# CITY OF ALBUQUERQUE

**Re: Star Limo Office**  
**800 Avenida Cesar Chavez SW**  
**Traffic Circulation Layout**  
Architect's Stamp dated 12-30-16 (L14-D059)

**Re: Star Limo Office Facility**  
**800 Avenida Cesar Chavez SE**  
**Traffic Circulation Layout**  
Engineer's/Architect's Stamp 12-02-16 (L14-D059)

TRAFFIC CIRCULATION LAYOUT PLAN

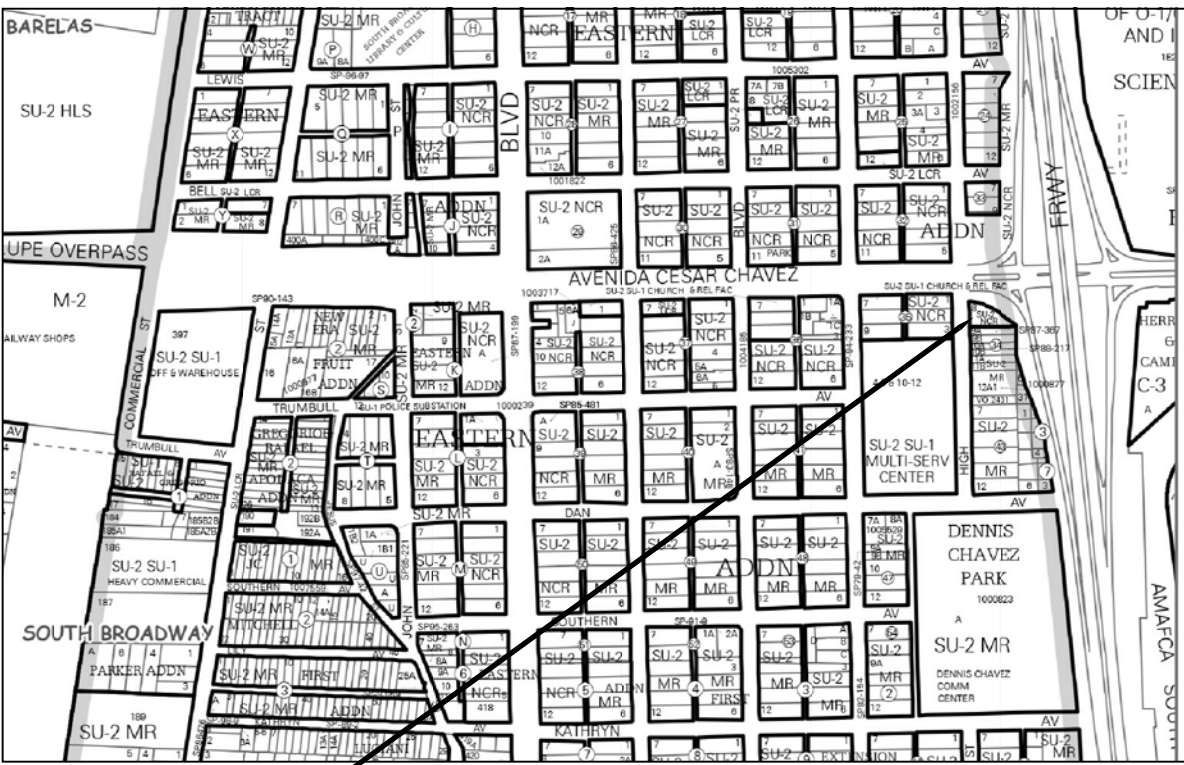
1. The ADA accessible parking sign must have the required language per 66-7-352.4C NMSA 1978 **"Violators Are Subject to a Fine and/or Towing."** Please call out detail and location of HC signs.
2. Please specify the City Standard Drawing Number when applicable. When replacing curb and gutter call out "standard curb and gutter" not the 6". Please use STD 2430 for sidewalk replacement.
